EPC STORMWATER REVIEW COMMENTS ARE SHOWN IN ORANGE BOXES WITH BLACK TEXT

2022 Financial Assurance Estimate Form (with pre-plat construction) mulching should match seeding quantity

PROJECT INFORMATION		
D49 Transportation Center	6/15/2022	
Project Name	Date	PCD File No.

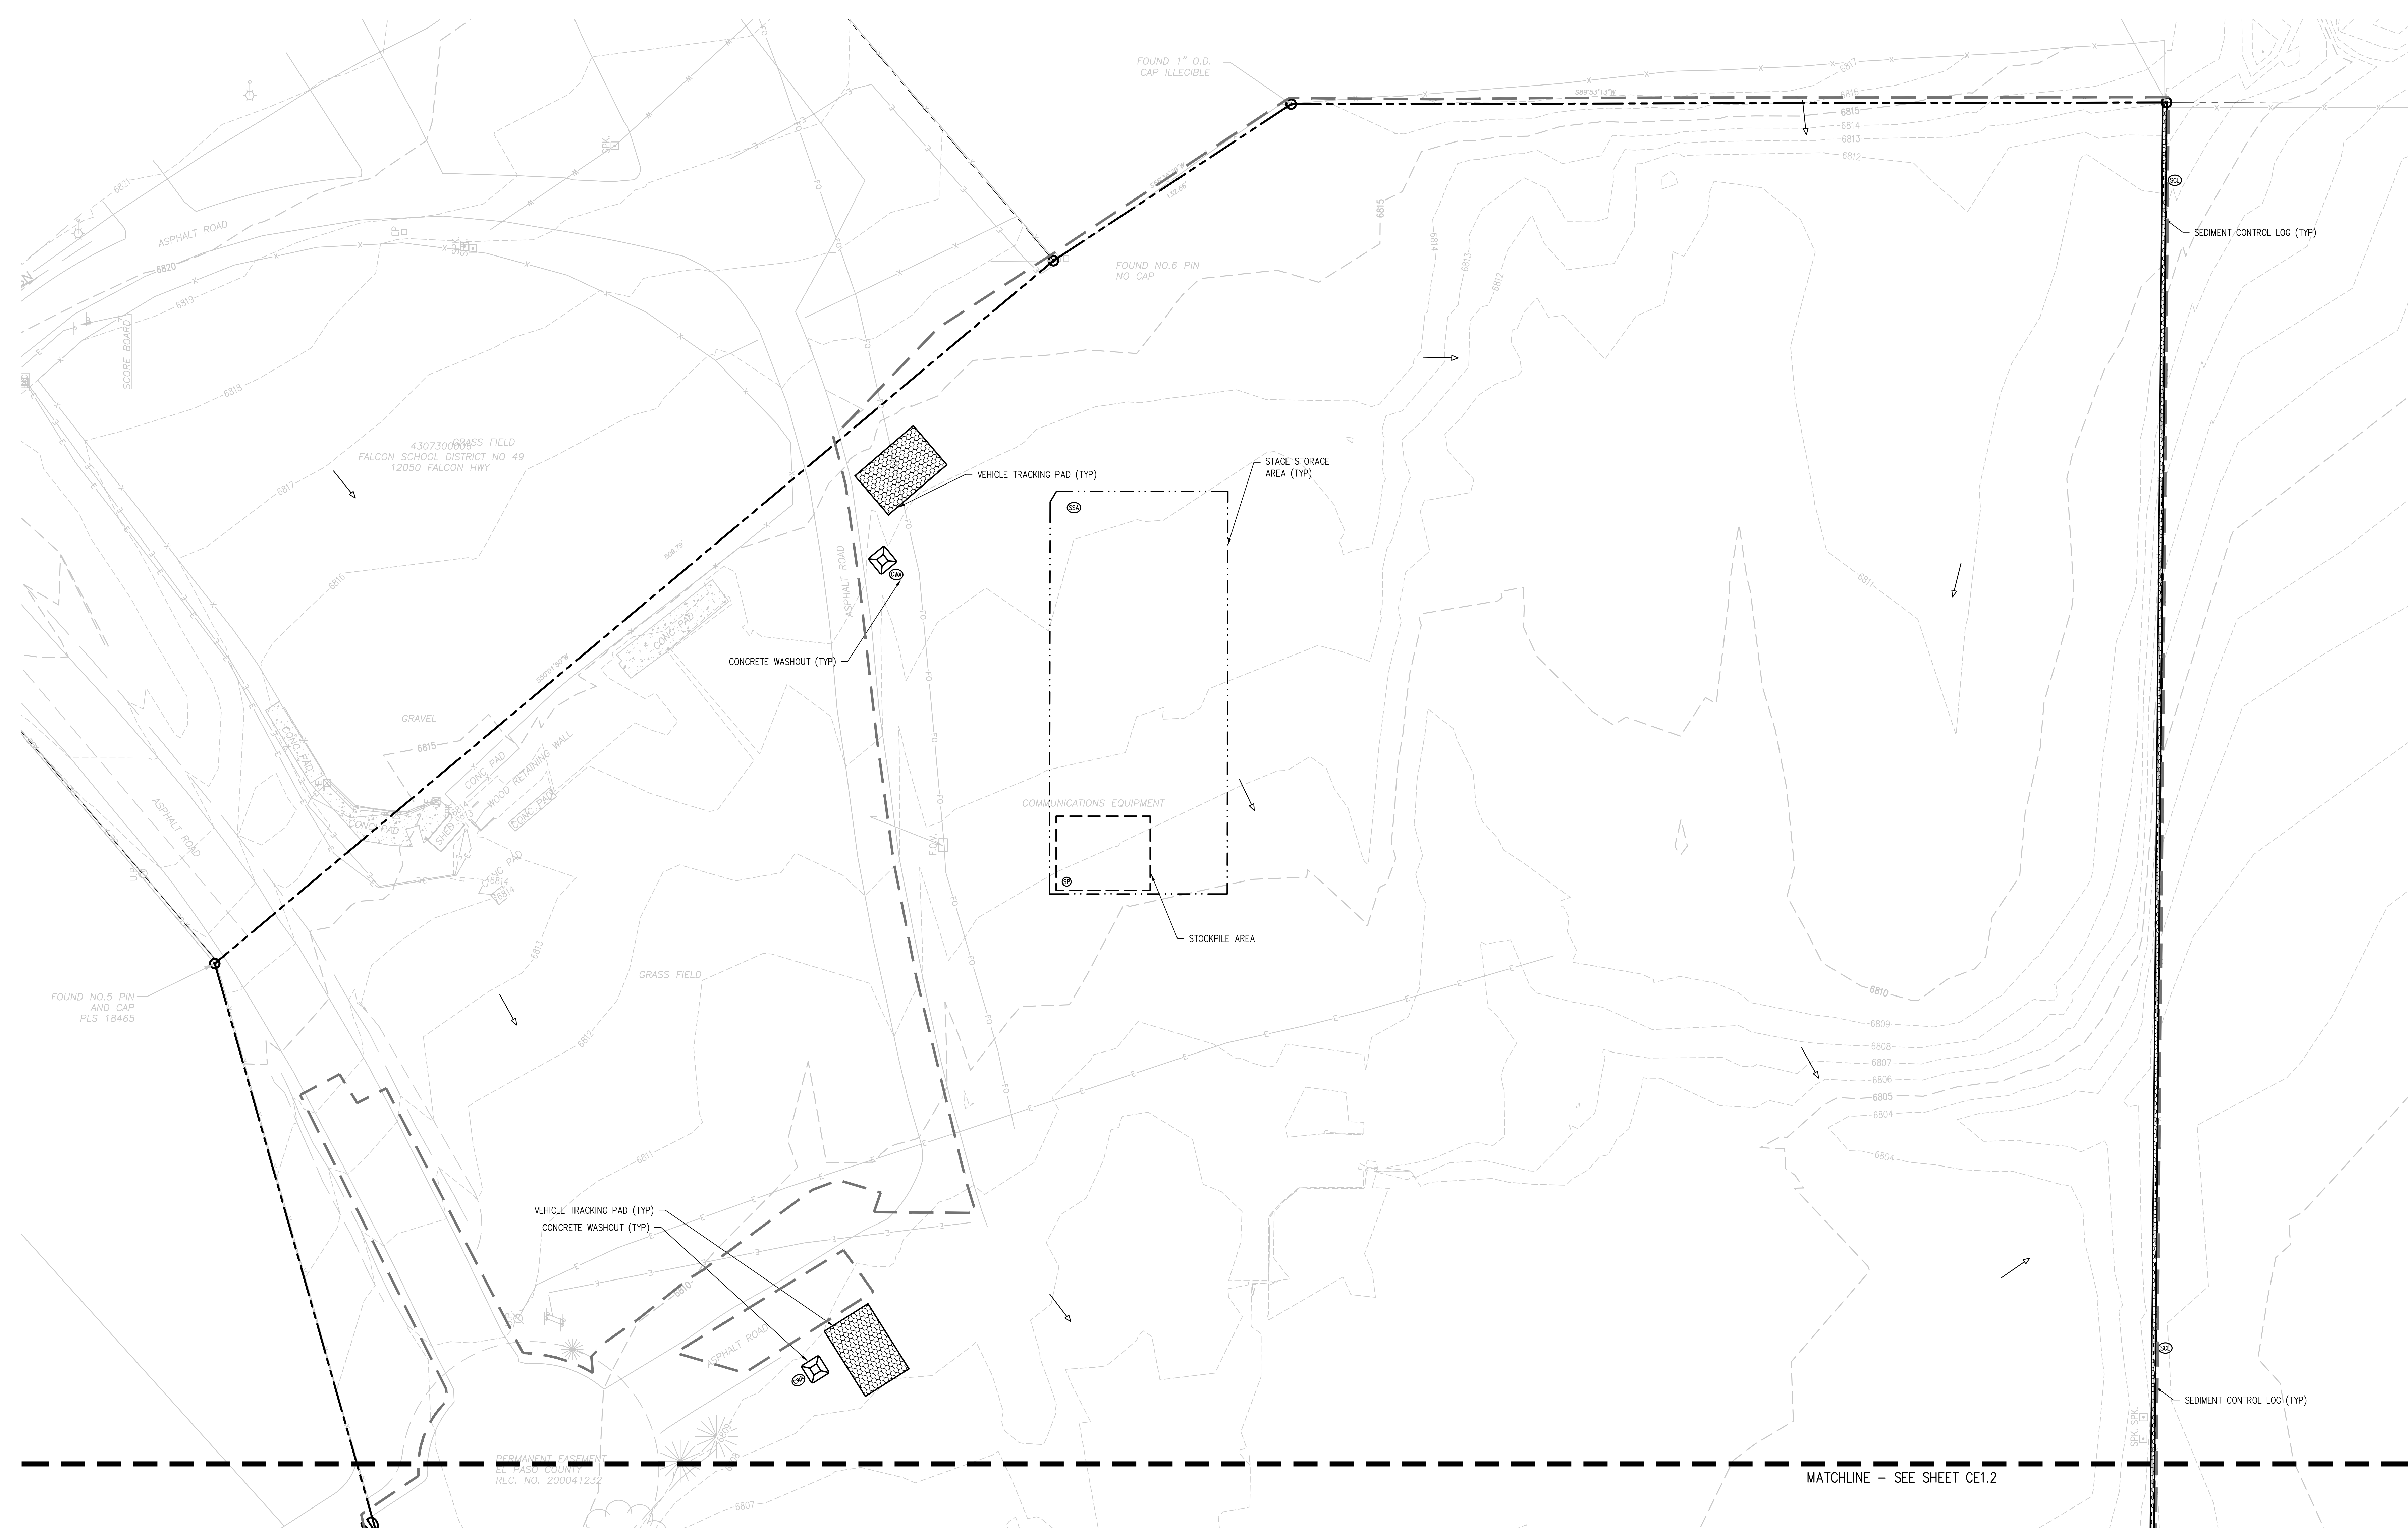
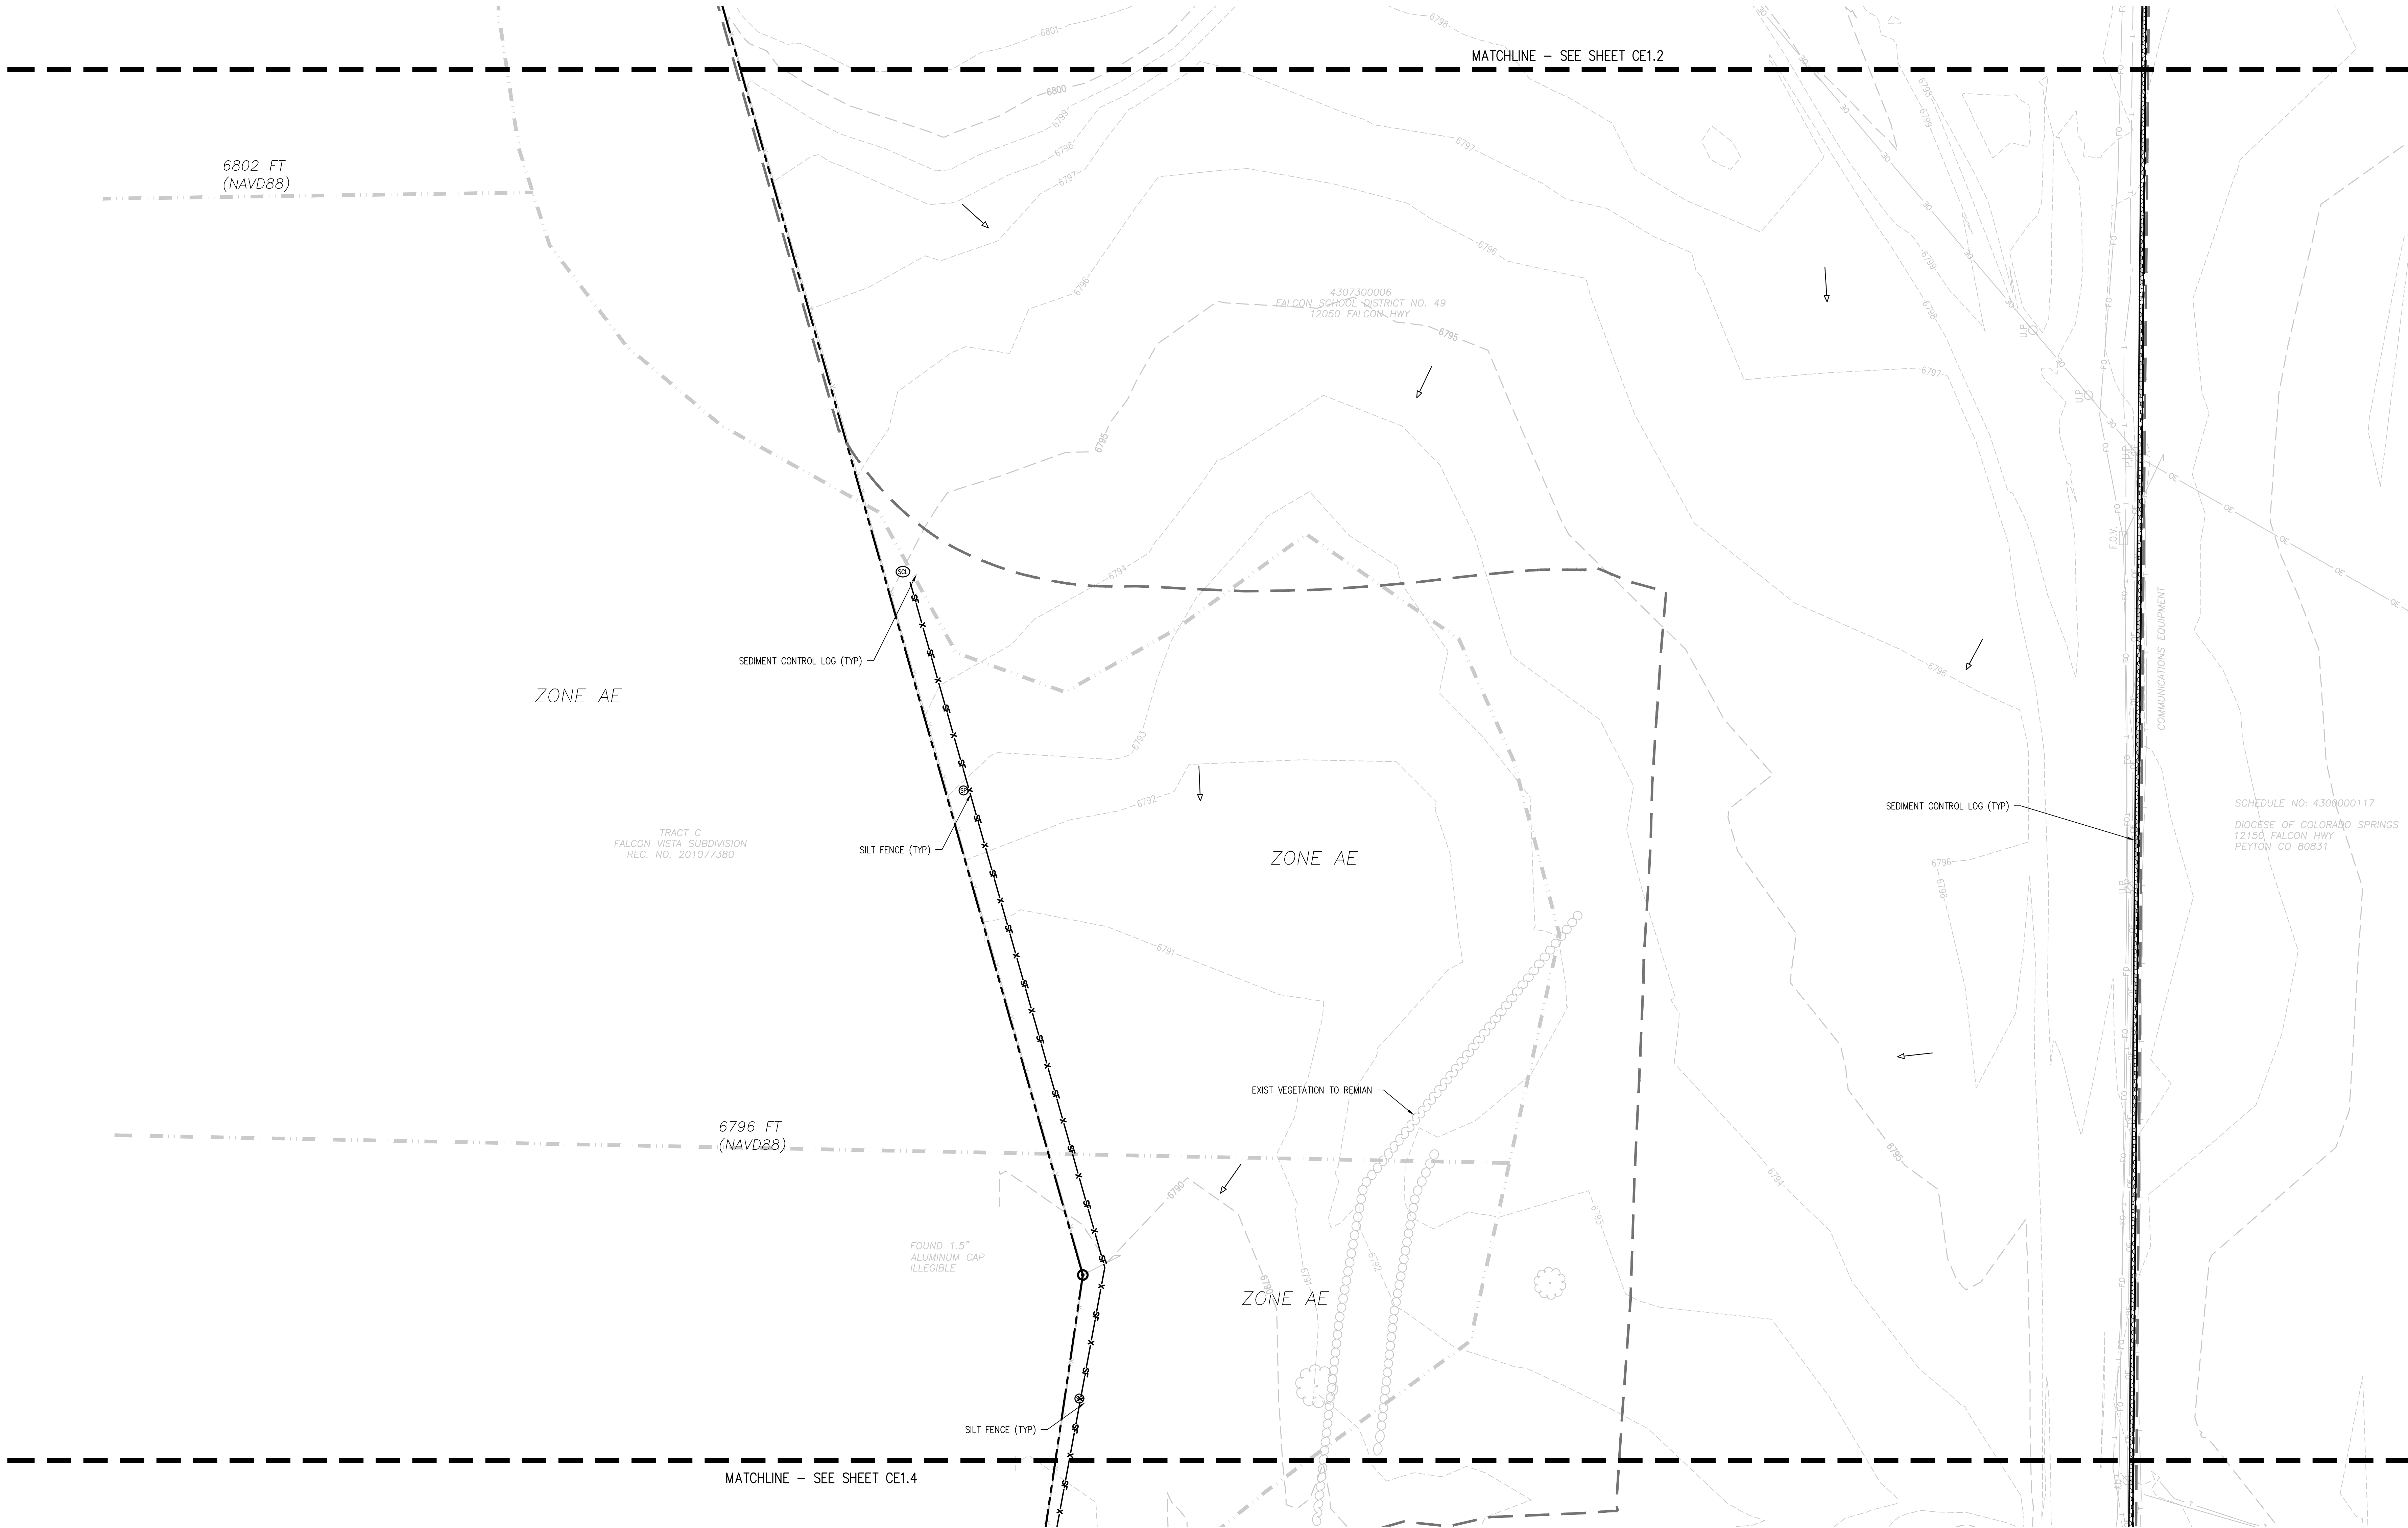
RCDs shown on figures
